Ribble Valley Borough Council
Housing & Development Control

Application no: **3/2021/0902**

Address: **5 Milbeck Close Longridge PR3 3LQ**

Proposal: **Proposed two storey extension to side and single storey extension to rear. Resubmission of 3/2021/0191.**

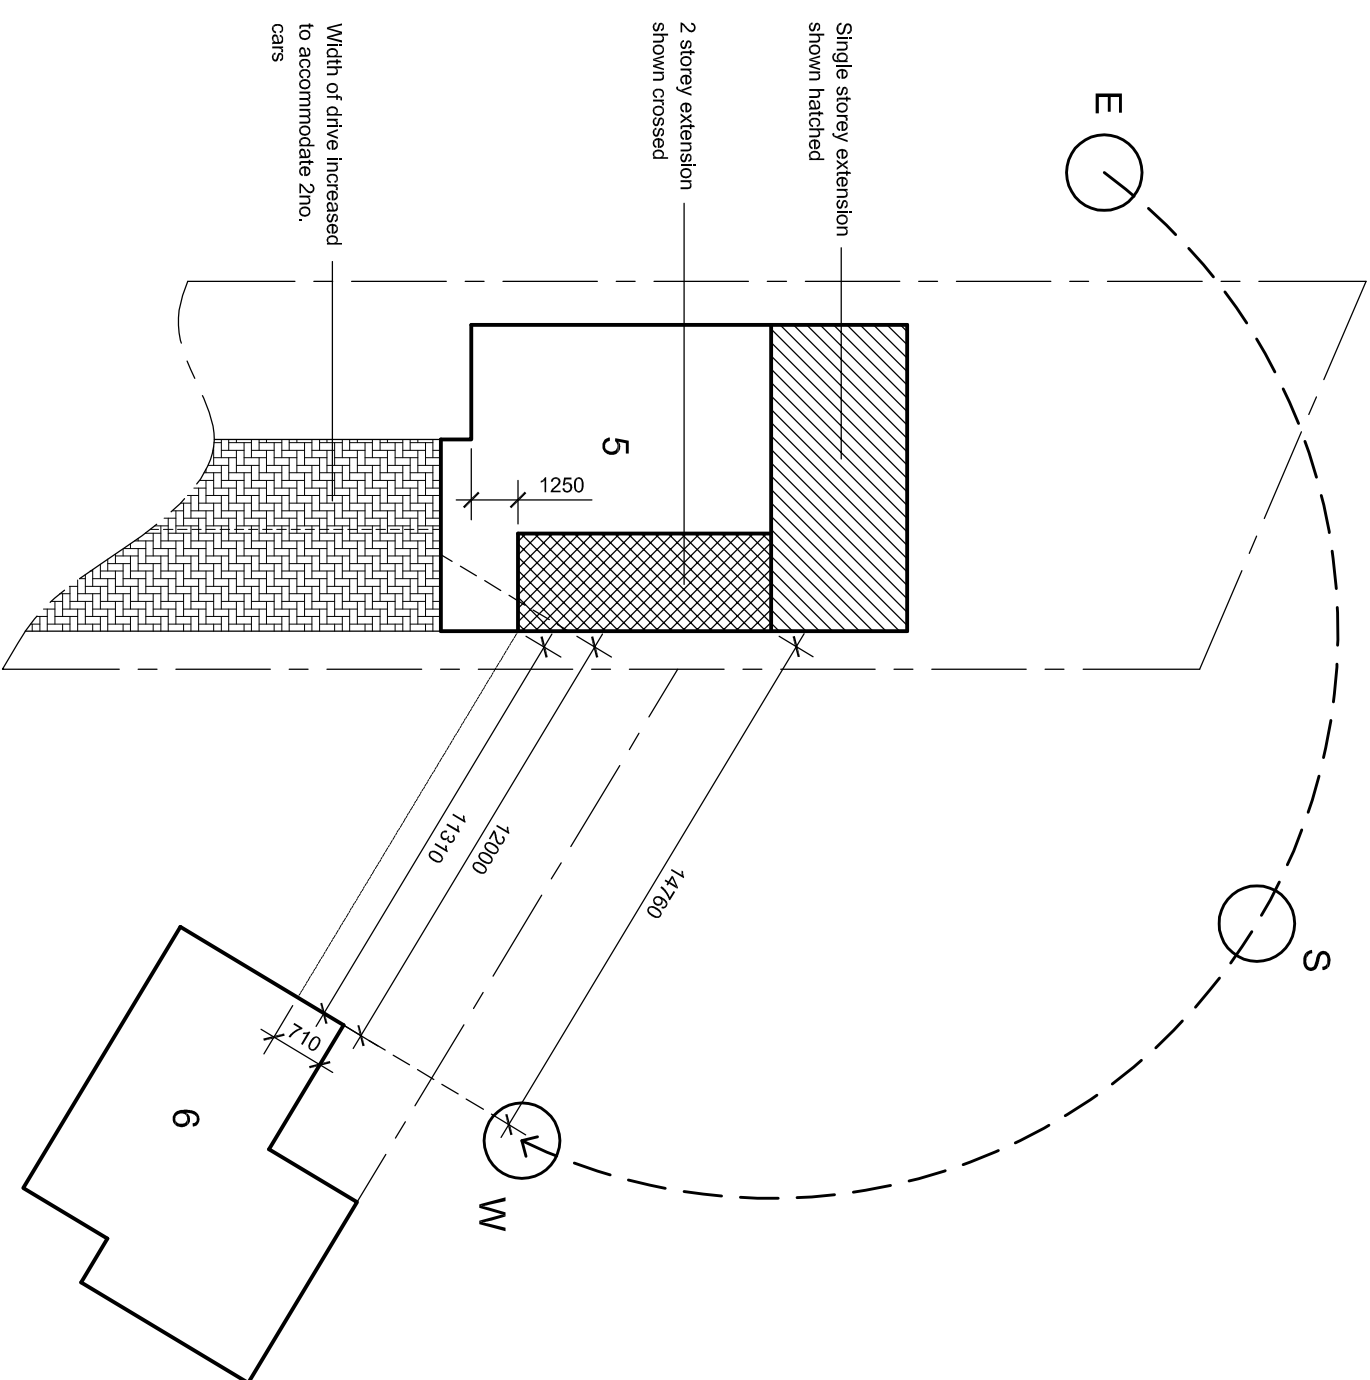
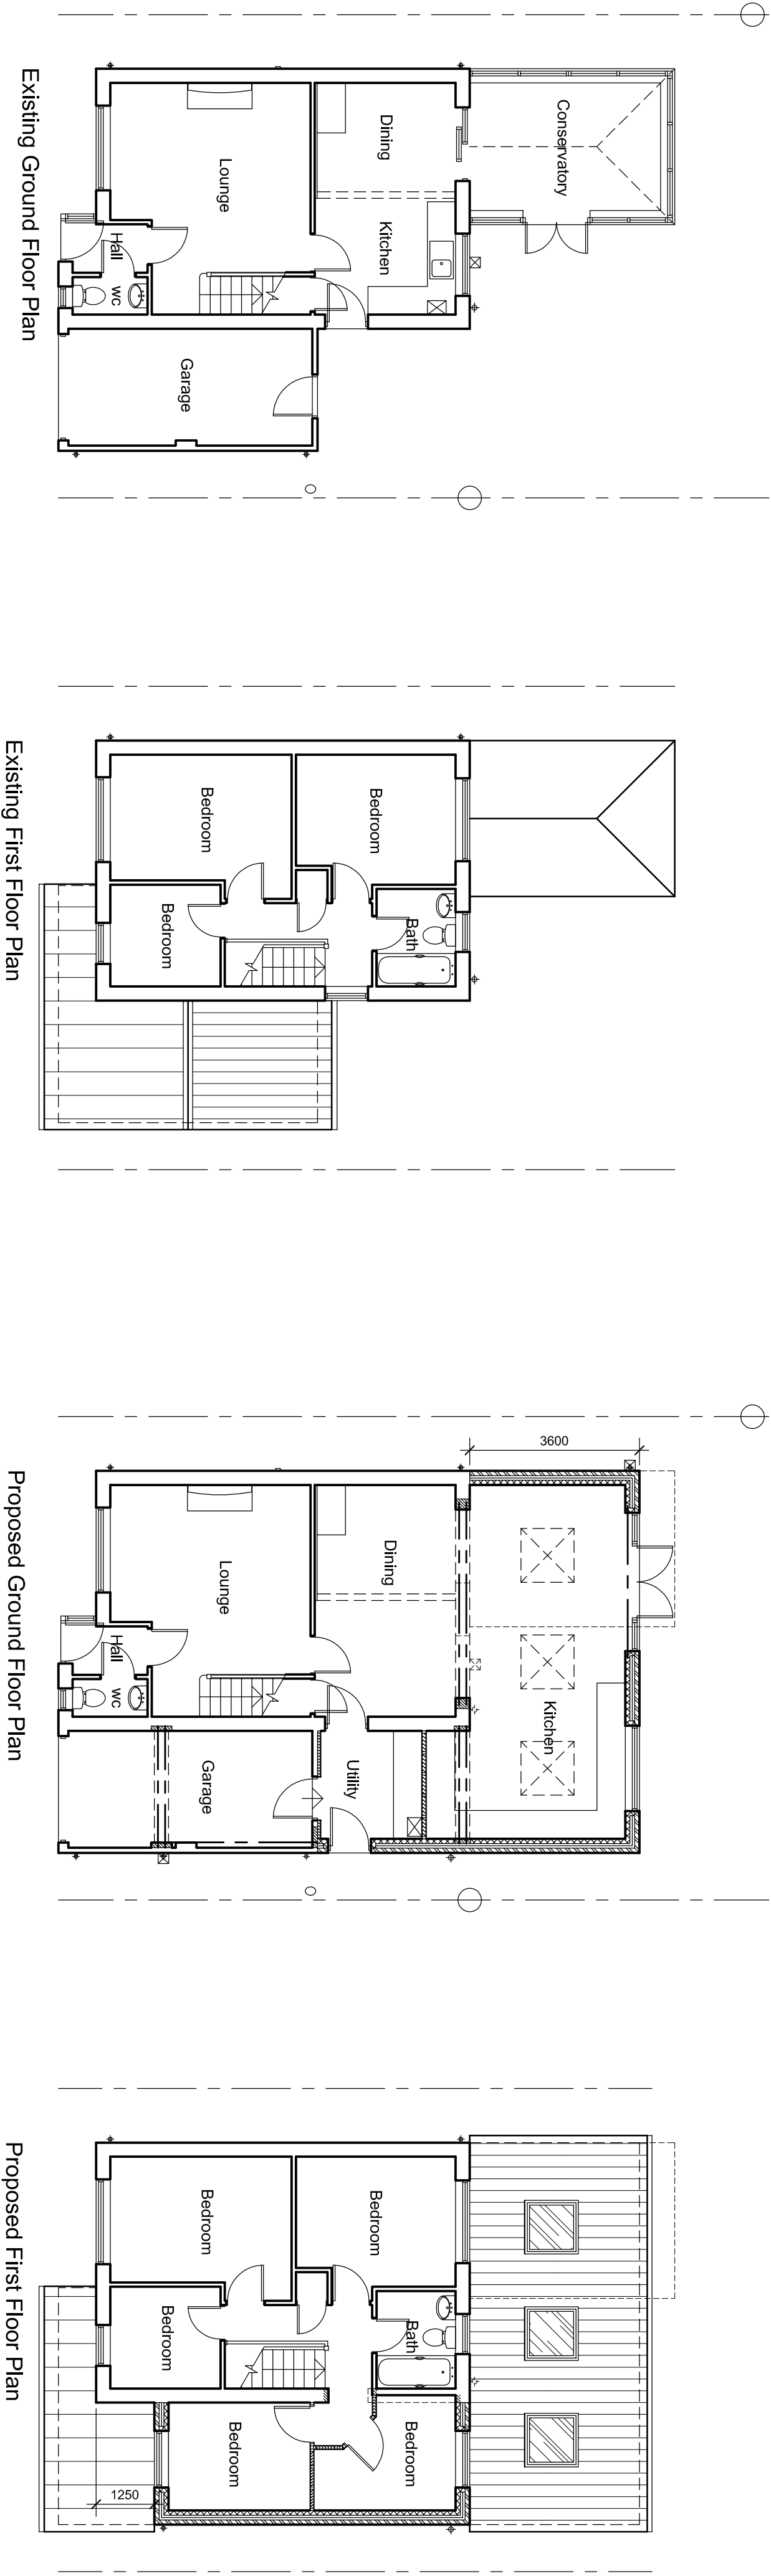
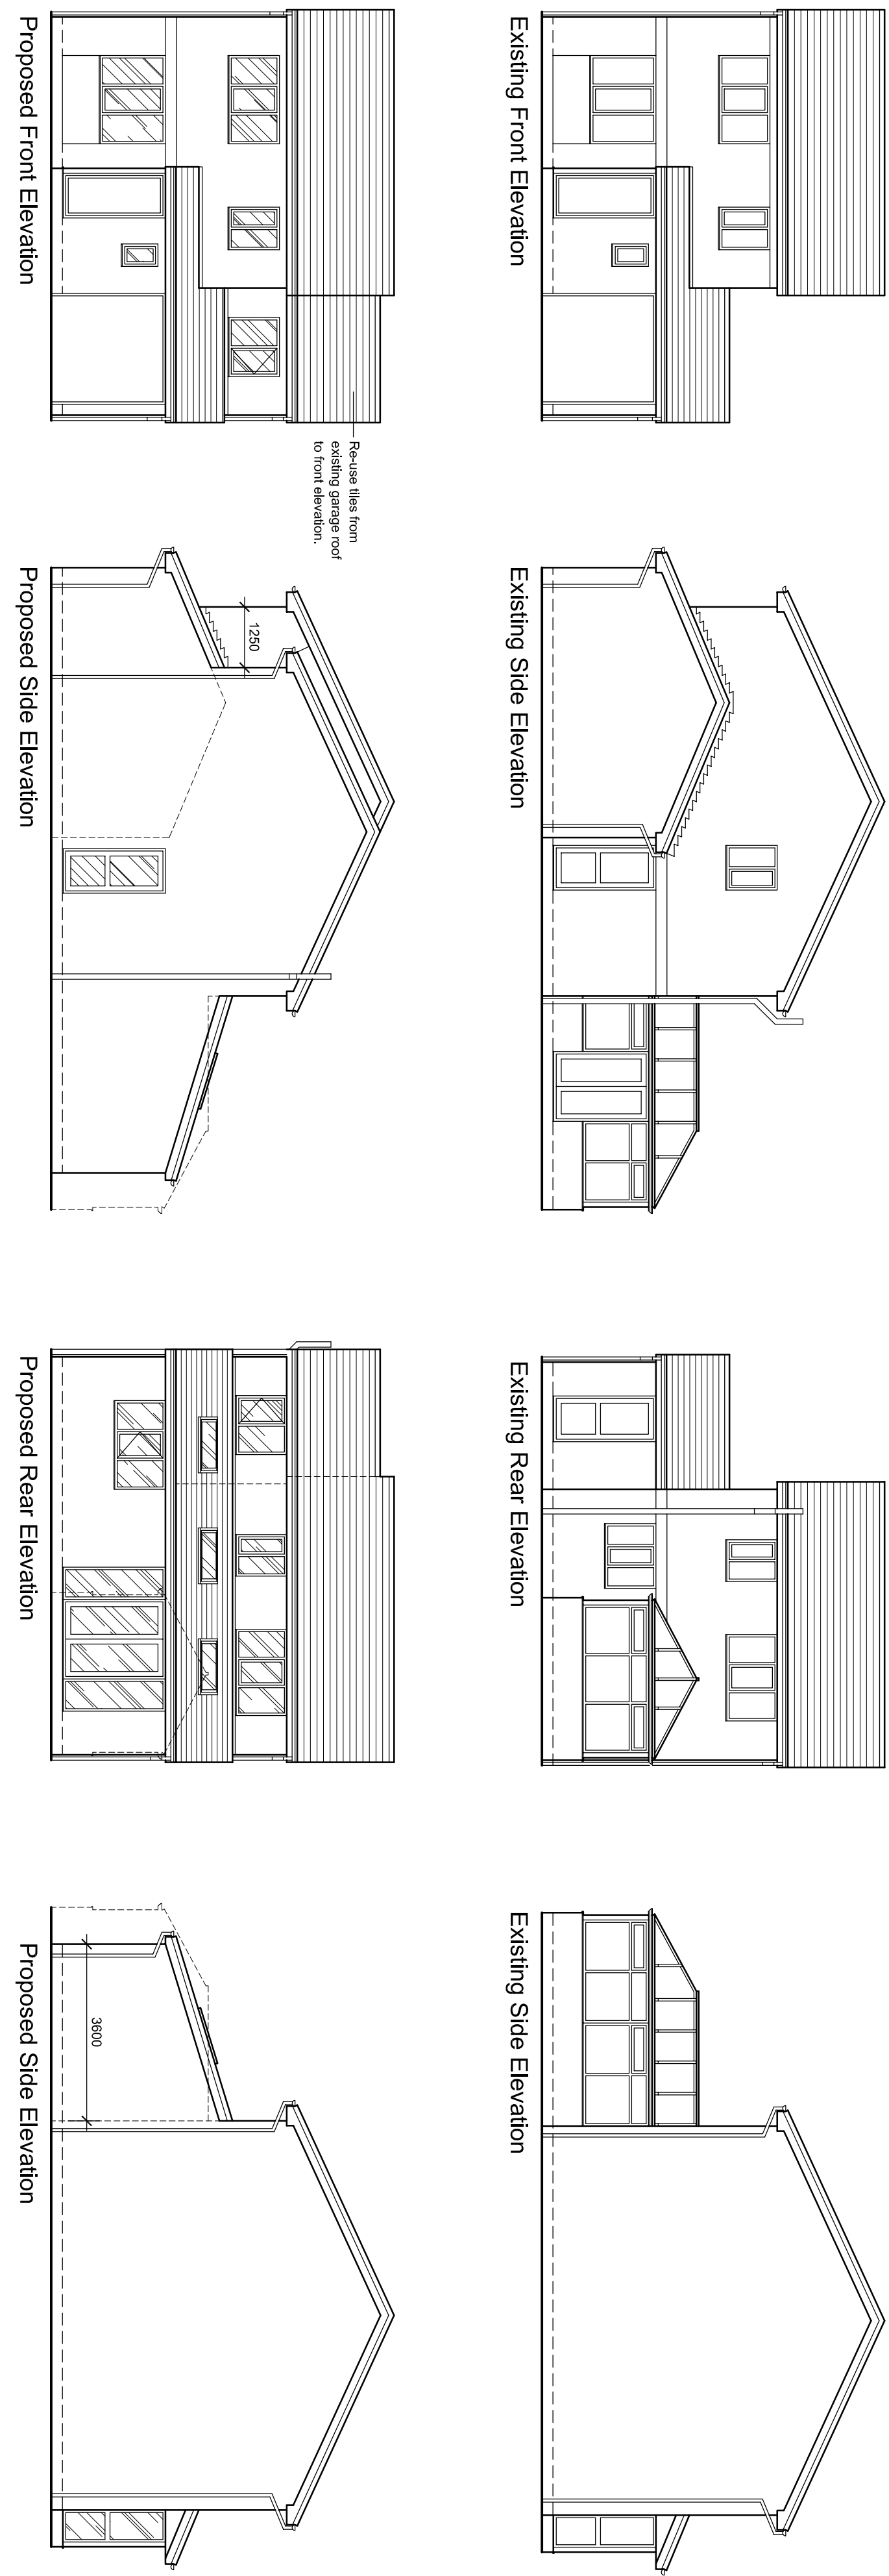
The LHA have reviewed the supporting documents and understands that the number of bedrooms in the dwelling will increase from a 3 bed to a 5 bed.

For a 5-bed dwelling to comply with the Joint Lancashire Structure Plan, the site is required to provide 3 car parking spaces.

The parking spaces will be located following the proposal, 2 on the driveway following the widening of the existing access which will include the need for a dropped kerb application and the use of the existing garage as a space.

It is worth noting that the dimensions of the single garage for a parking space do not comply with the LHAs guidance which requires a single garage to measure 6m x 3m. However, with the garage being existing and used as a parking space for the 3-bed dwelling the LHA have no comments to make with it being a pre-existing situation.

The LHA do advise the Applicant that should the proposed widening of the access conflict with the service chamber located adjacent to the existing access on the footway, then the Applicant will be liable to the full cost of strengthening it in collaboration with the utility company.

The development hereby permitted shall not be occupied until such time as the access drive (and any turning space) has been surfaced with tarmacadam, or similar hard bound material (not loose aggregate) for a distance of at least 5 metres behind the highway boundary and, once provided, shall be so maintained in perpetuity.
